M54 to M6 Link Road
TR010054

**8.8 LIU(E) Draft Statement of Common
Ground with Mark Commins & Tracey
Commins**

**M54 to M6 Link Road
Development Consent Order 202[]**

Regulation Number	Regulation 5(2)(q)
Planning Inspectorate Scheme Reference	TR010054
Application Document Reference	8.8 LIU(E)
Author	M54 to M6 Link Road Project Team and Highways England

Drawing Title
**FIGURE 11.1
 NOISE LOCATION PLAN**

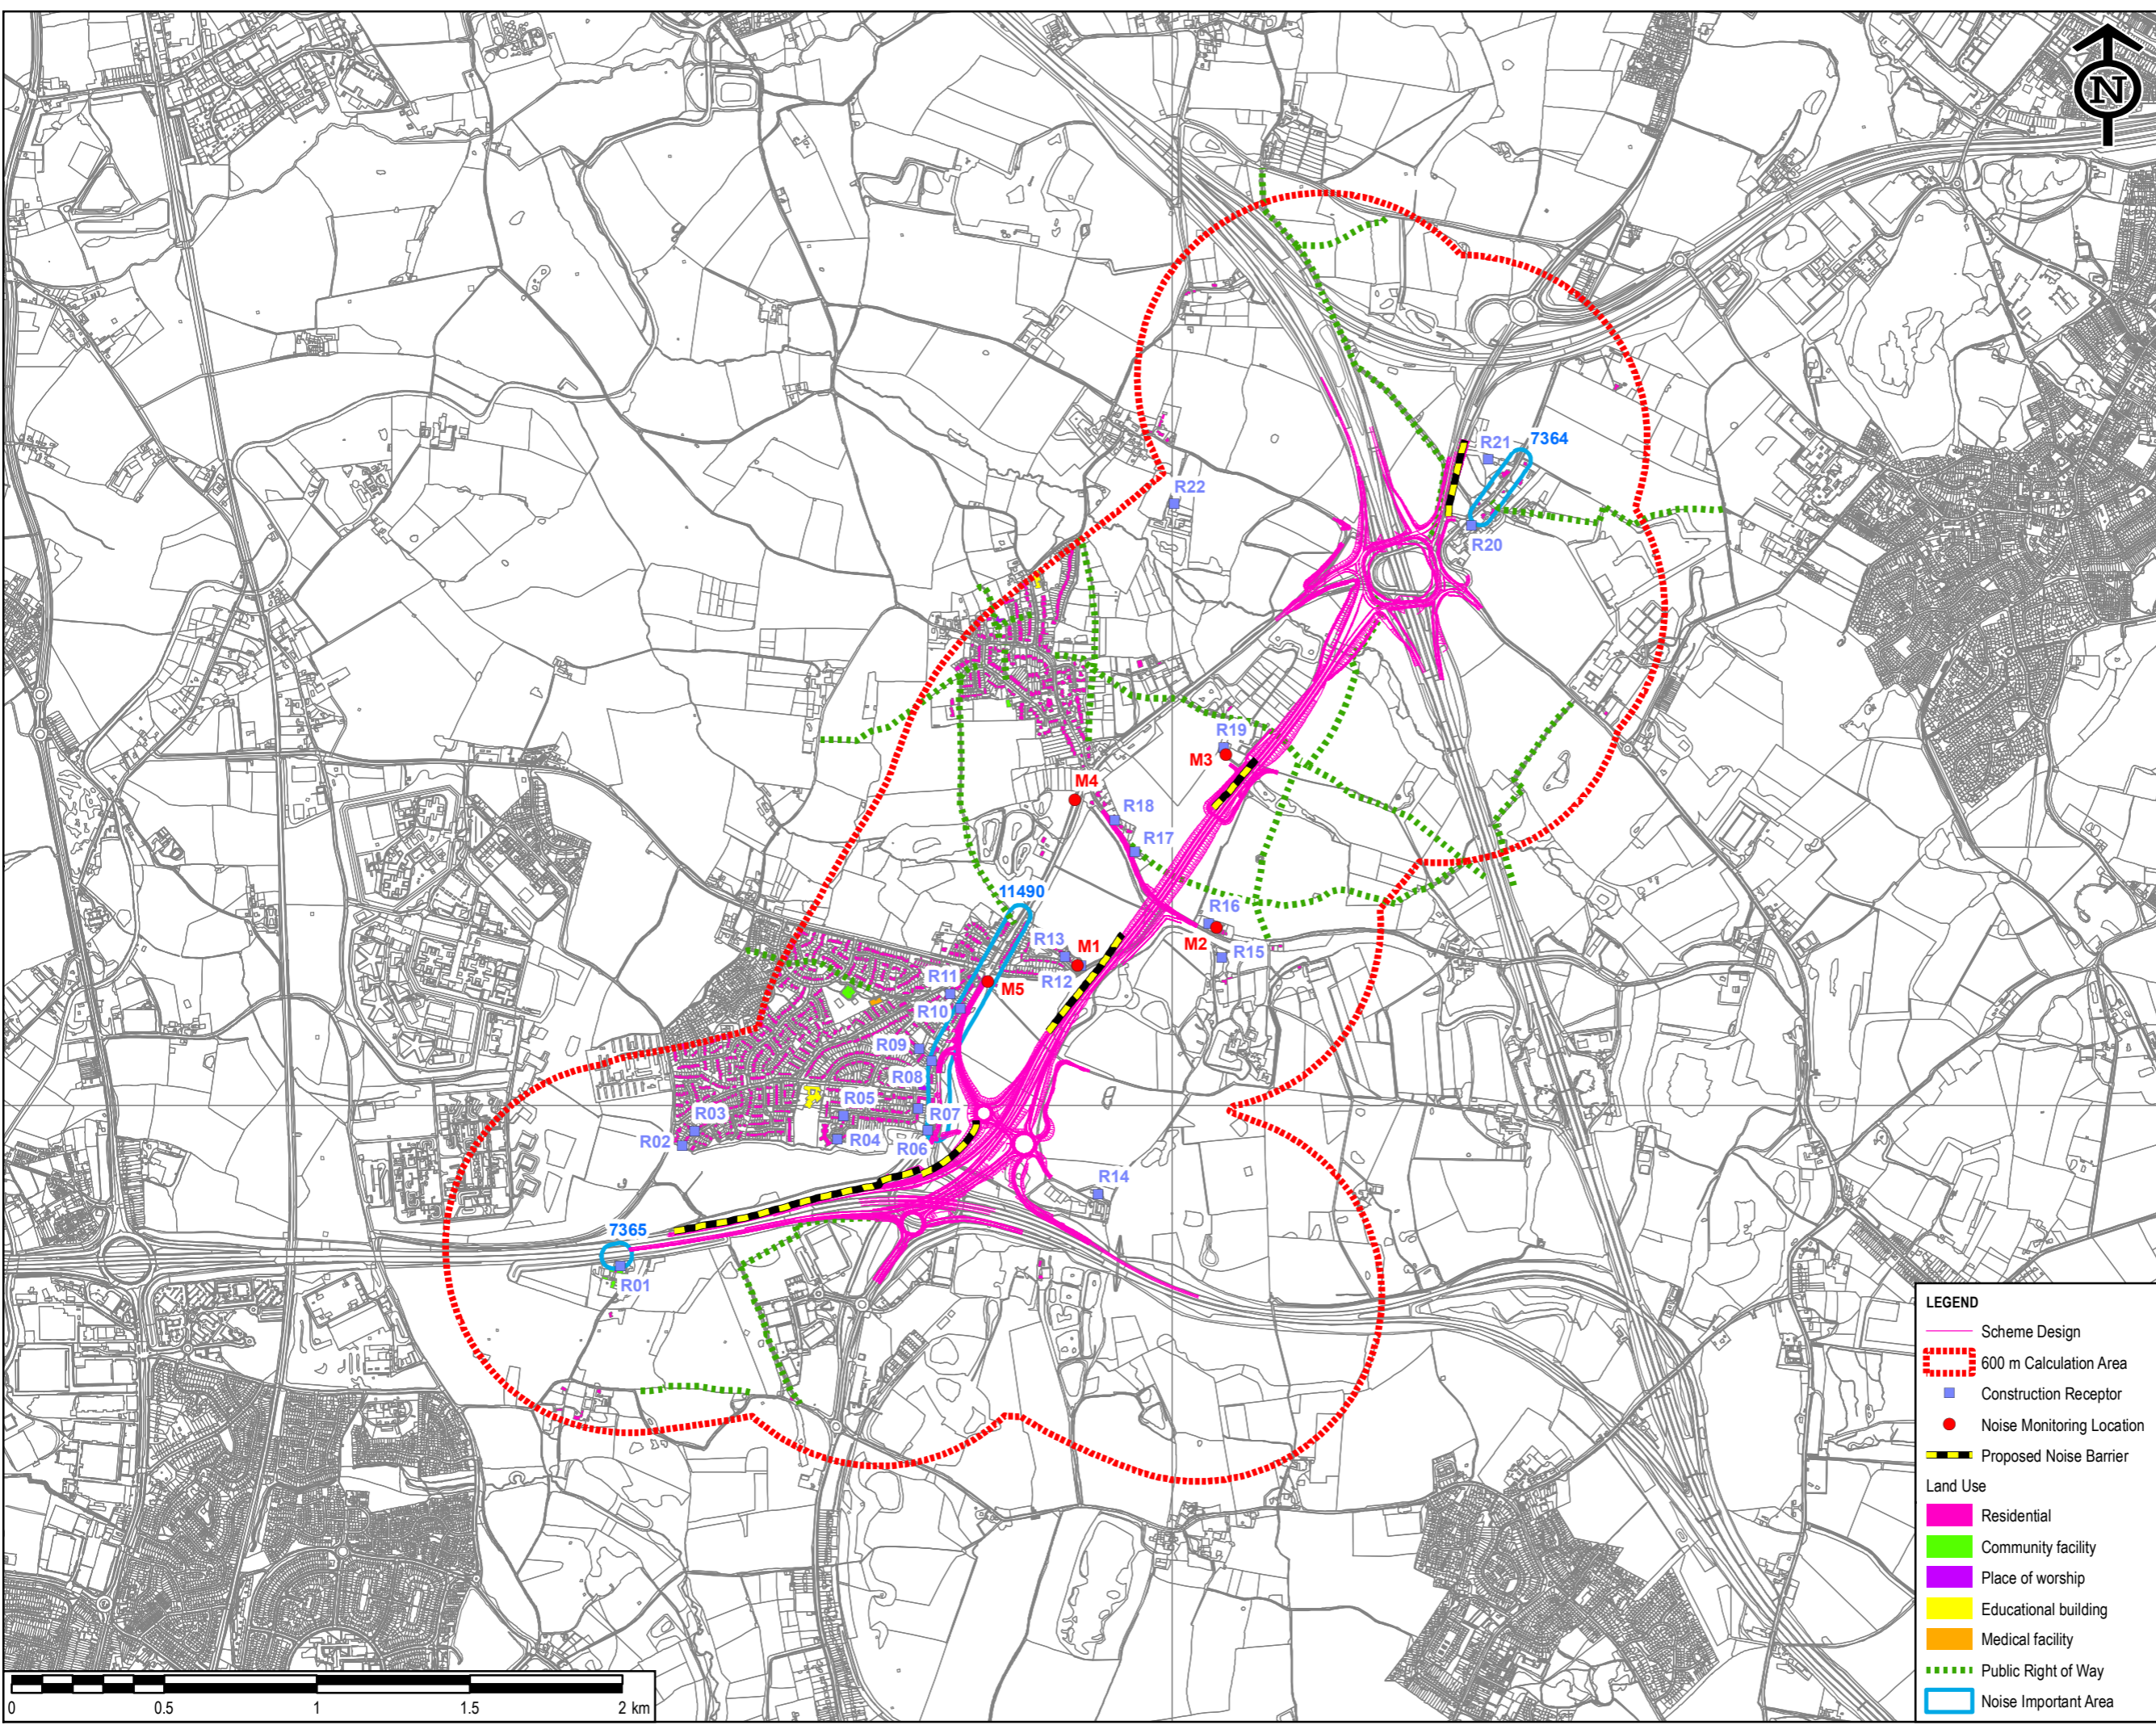
<p>Noise monitoring</p>	<p>Question raised why noise monitoring surveys were not conducted from the club house</p>	<p>Noise monitoring has been undertaken as part of the Environmental Impact Assessment and the results are reported in Figure 11.1 of the Environmental Statement</p>	<p>Agreed (To be confirmed by landowners)</p>	<p>High</p>

Issue	Landowner comment	Highways England Response	Status	Agreement likely (app) ¹	Agreement likely (IP)
		<p>[TR010054/APP/6.2]. The noise monitoring is used to develop an understanding of the general noise climate in the vicinity of the Scheme, and as part of a validation exercise for the prediction model; it is not used to establish baseline conditions for individual receptors. The traffic noise levels and any subsequent change in the traffic noise levels as a result of the Scheme are then predicted using the model. In order to quantify traffic noise, Highways England would normally want to avoid siting monitoring equipment near specific known noise sources which might distort the numeric results (e.g. a building which may generate entertainment noise).</p>			
Air quality impacts	Air quality assessment at Brookfield Farm	<p>Based on the affected road network, sufficient monitoring data is available from Highways England and local authority sources to confirm the model performance, without the need for further monitoring at this stage of the design. The assessment on air quality in Chapter 5 of the Environmental Statement [TR010054/APP/6.1] demonstrates that no properties will experience air pollution levels above national air quality objective values post construction as a result of the Scheme. The significant reduction in traffic along the A460 will potentially enable future improvements</p>	Agreed (To be confirmed by landowners)	High
